DELEGATED ITEM FILE REPORT - APPROVAL

Application No:	3/2015/0197
Development Proposed:	Proposed window at ground floor on the side elevation. 4 Park Mews, Gisburn, BB7 4ES.

Proposed Side Elevation

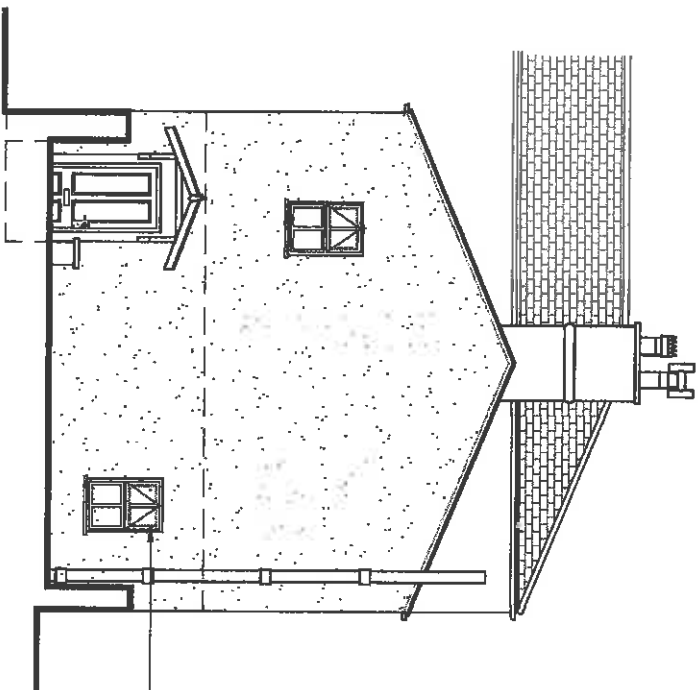
The proposed works consist of the insertion of a new ground floor window opening into the South West facing gable end of the property. The new opening will be created at ground floor level adjacent to the existing entrance door and this will serve the living room.

Planning permission has previously been granted for a first floor window opening directly over the existing entrance door which serves an existing bathroom, planning application 3/2013/0240P. This window has been inserted in accordance with the details approved and is narrower in width than the window illustrated on both the existing and proposed elevations drawings submitted with this application.

The existing gable end elevation contains a single door opening with a narrow first floor window above at the south east side of the gable. At present the existing door on the gable elevation is relatively inconspicuous. In contrast, the first floor window recently allowed is more conspicuous; however, it is my opinion that the harm to the solidity of this gable has been done by the insertion of the first floor window present. The window proposed would match in height and width dimensions to this first floor window and being located diagonally opposite, it is thus considered that the harm to the solid to void ratios of this prominent gable have been minimised. In addition, the materials of the window are to match the existing timber windows, and would therefore be respectful of the traditional window materials. On balance, I consider the proposal to cause limited harm to the building itself, a designated heritage asset and this part of the conservation area.

For these reasons, I thus consider that this amended proposal to have an acceptable impact on the character, appearance and significance of the conservation area and subject to a condition ensuring timber windows I recommend the proposal be approved
